From: Amanda Scholes on behalf of Planning.Responses
Sent: 08 November 2017 08:47
To: Planning Scanning
Subject: FW: Planning Consultation on P/117/17/DOC

APPLICATION NO: P/117/17/DOC

Site Address: Sefter Farm Pagham Road Pagham PO21 3PX

Description of Works: Application for approval of details reserved by condition imposed under planning permission P/76/16/PL relating to condition No. 15 (Surface water drainage scheme)

Sections D - D, E - E and F - F

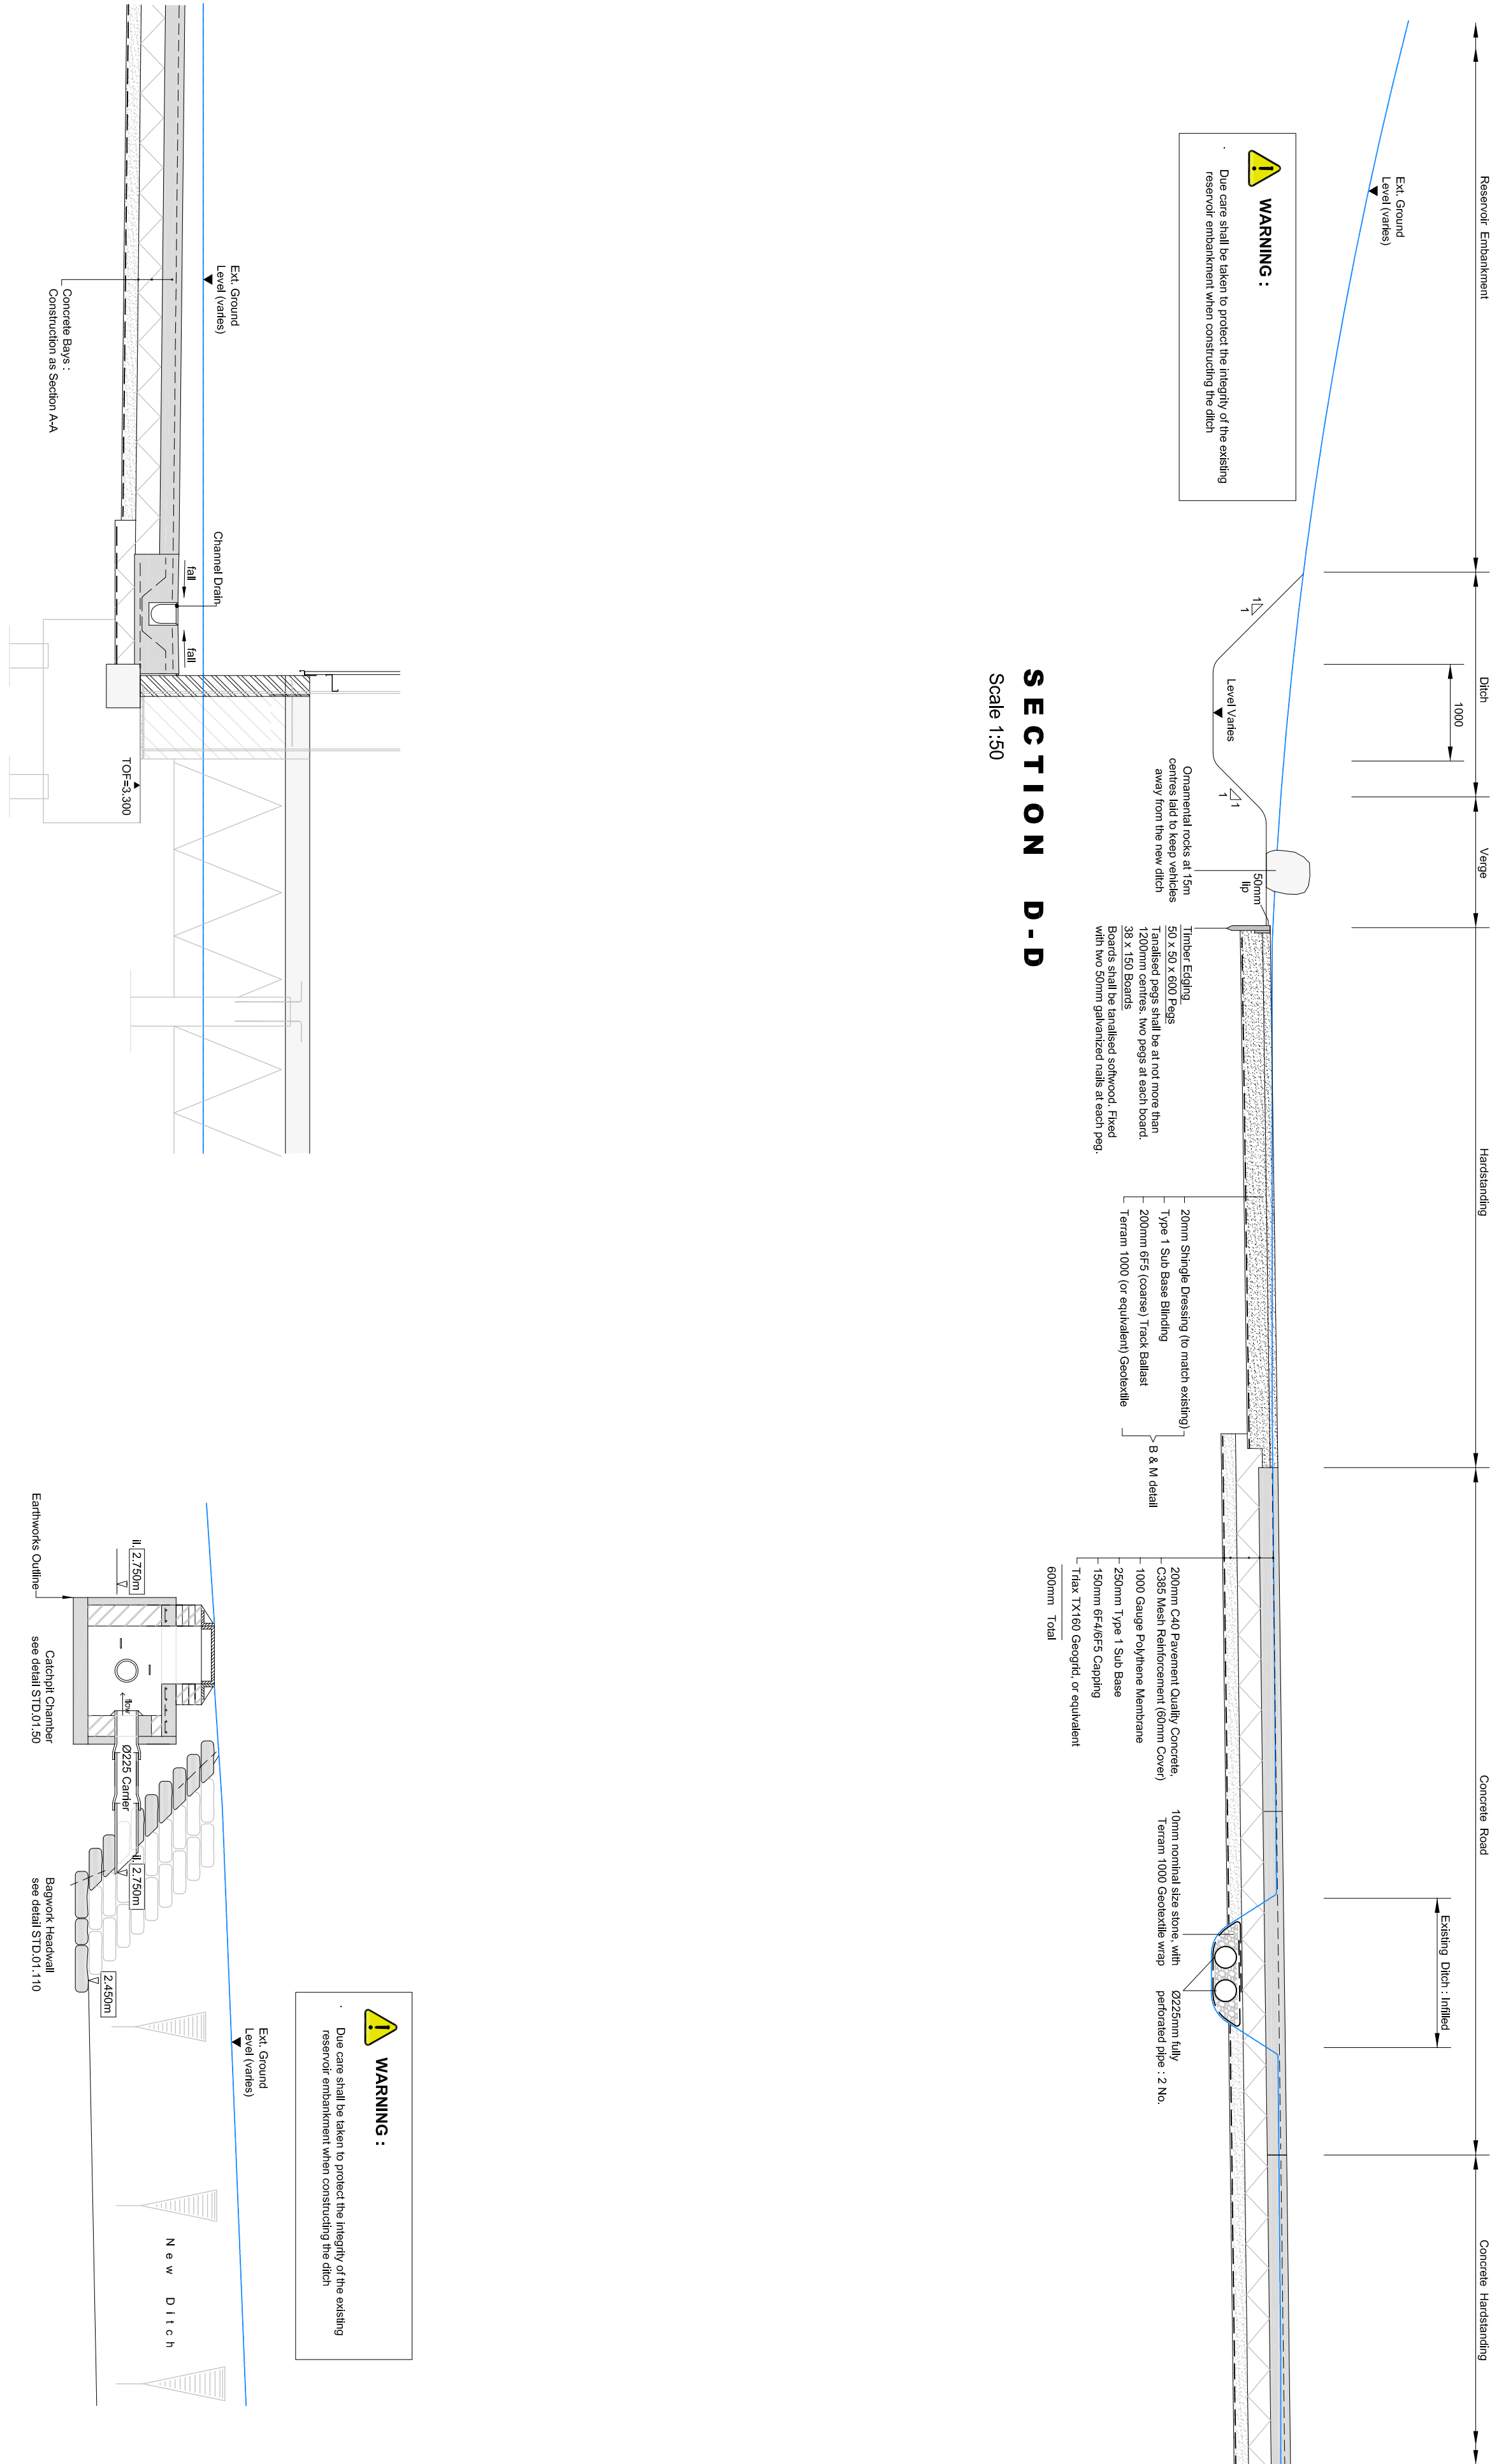
10. Land drainage consent is required for the proposed alterations to existing ditches, as well as new ditches. Full construction details required ie. ditch profile, manholes (sumps required), pipe bedding/material, headwalls, etc. Ninety degree bends in manholes need to be avoided. Specify pipe gradients. All heads of runs require head manholes, although is there a need for the perforated pipes upstream of manhole S6 and adjacent to the proposed gravel car park? Pipe upstream of manhole S7 has no fall. Twin 225mm diameter pipes required between manhole S6 and the ditch headwall, and downstream of manhole S5. What will be draining into the new ditches/culverts? Are perforated pipes necessary? The existing 300mm diameter culvert to the east of the proposed car park/access road and immediately downstream of the new ditch, appears to have a backfall?

CLIENT	Barfords of Boley
PROJECT	New Packhouse Selfer Farm, Pagham Drainage General Arrangement

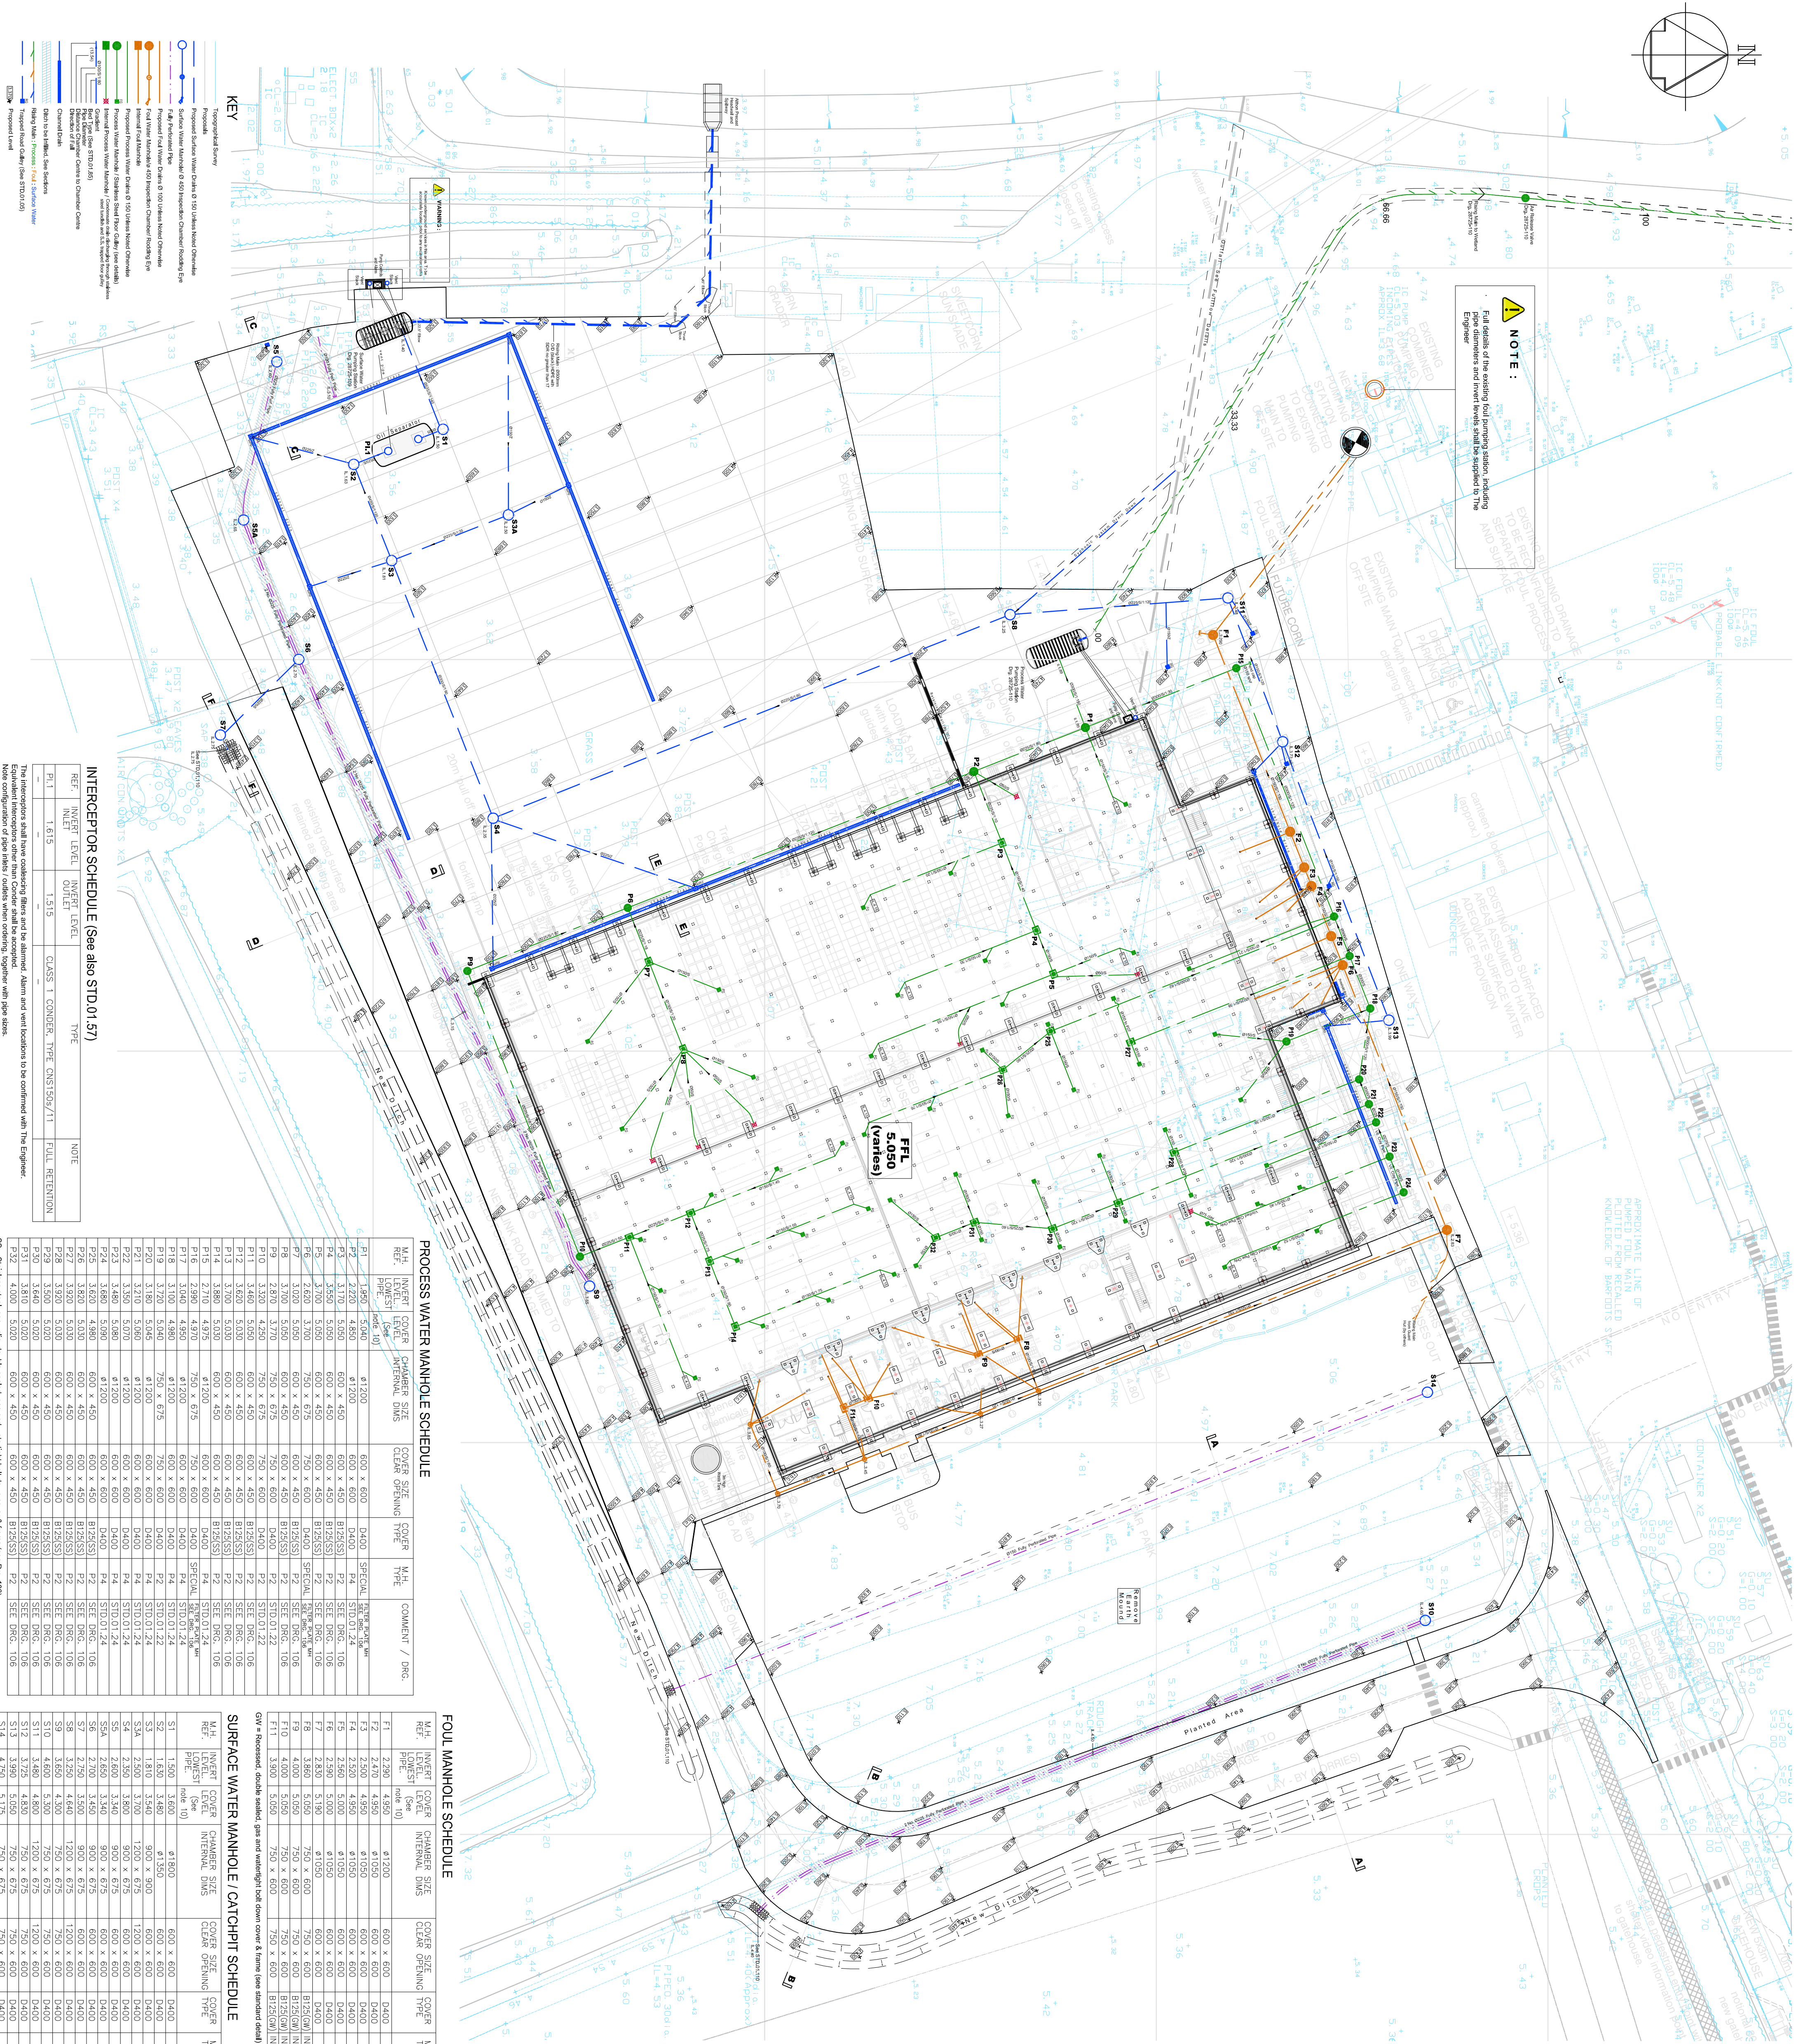
1. A statement should be provided regarding the overall drainage strategy for this development.
2. It appears that some surface water runoff is being collected and pumped to an adjacent existing reservoir, for assumed recycling.

3. Full technical/construction details are required for the pumping station/rising main and other associated infrastructure ie. oil separator, manholes, fork lift wash sump, headwalls, etc.

4. Details are required in respect to the capacity of the reservoir and its ability to accept additional flows, together with any overflow arrangements.

5. Hydraulic calculations/catchment plan are required to support the pumping/storage proposals.
6. Impermeable areas adjacent to the north elevation of the building are shown to connect to existing surface water drains – more information/detail is required in this respect.

7. No drainage information has been supplied for the new access road.
8. No drainage has been provided for the gravel car park – more information is required on the construction proposed but it is likely that some form of drainage will be required.

11. Further clarification is required on existing infrastructure, ie. where the perforated pipes in the south west corner appear to discharge.
12. Little information has been provided in respect to the proposed wetland/reedbed/process pumping station.
